Lead Local Flood Authority

Date 4th August 2026

RE: WA/18/26/PL - Land off Arundel Road Fontwell

This is a full application for the erection of 64 residential dwellings with access off Arundel Road, together with associated parking, open space, play space, landscaping, drainage and infrastructure.

Drainage Plans and Calculations

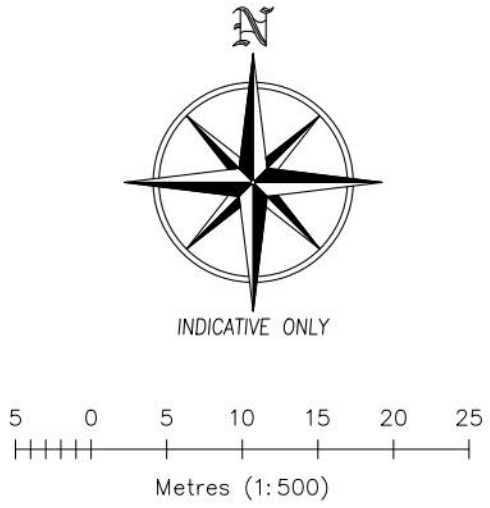
While infiltration is not being used to drain the site, there are several instances where the drainage strategy implies infiltration is still being used. For example, paragraphs 1.3.23 and 1.3.34 and the Contributing Areas Plan and Drainage Strategy Plan all still mention infiltration or infiltration basin. This does not accurately reflect how the site is proposed to drain. There may be other instances where this is an issue. It is also important that this is reflected in any other relevant document submitted under this application, to ensure documents are consistent.

The infiltration basin is still included in the Contributing Areas plan.

Infiltration is not being used to drain the site, due to the groundwater levels. As mentioned several times, all references to an "infiltration basin" shall be removed from all drawings, as this does not reflect the function of the basin.

In the Contributing Areas Plan, reference is still made to an “infiltration basin”.

It is unclear whether the design of the attenuation basin has considered the high groundwater levels. We request a cross section of the basin and porous paving, to ensure groundwater is considered in the design of SuDS features.

This is not adequately addressed. Currently, the cross section shows that the base of the basin is where the highest groundwater level is located. There does not appear to be any evidence of how the groundwater has been considered in the design of the basin. It is important the capacity of the basin is not impacted by high groundwater levels, as flood risk could increase elsewhere.

The liner does not appear to be included in the basin cross section.

In addition, the permeable paving cross section is missing.

This has not been provided still.

It is unclear whether freeboard from the 1 in 100 year plus climate change event has been included in the basin design.

To ensure the application is in accordance with national planning policy and guidance, residual risk should be safely managed. There is currently 50mm between the maximum water level in the 1 in 100 plus climate change event (design event). There does not appear to be any plans showing finished floor levels. This therefore means the residual risk if the capacity of the basin and associated infrastructure were exceeded has not been adequately addressed.

We require the updated drainage plan.

A minimum 3m easement for the attenuation basin is required, for maintenance access.

The easement shall go around the entire basin, rather than part of it. For the side near the building, it is unclear whether the basin can be safely maintained. As these issues could affect the layout and scale of the site, it would not be reasonable for the above to be covered via conditions at this stage

As requested, we require the easement to go round the entirety of the basin.

As these issues could affect the layout and scale of the site, it would not be reasonable for the above to be covered via conditions at this stage.

We don't understand this point. Could clarification be provided.

The groundwater monitoring results were shown in the FRA. The pond was in the location where the groundwater was at its lowest through the winter testing. This was at a depth of 1.5m BGL. Given a ground level of 31.6m AOD, the maximum groundwater level can therefore be seen to be 30.10m AOD. This coincides with the base of the pond so will not affect the capacity of the lined pond.

We can provide a typical permeable paving section.

Levels are shown on the drainage plan. Additional levels have been shown on the adjacent dwellings which indicate a maximum freeboard of 0.3 above the 1 in 100 year plus climate change level.

We have currently shown a 3m easement for maintenance for the inlet and outlet structures. Any other maintenance can be carried out from within the basin.

Notwithstanding the above we can tweak the layout to provide the 3m easement around the entire perimeter as below.
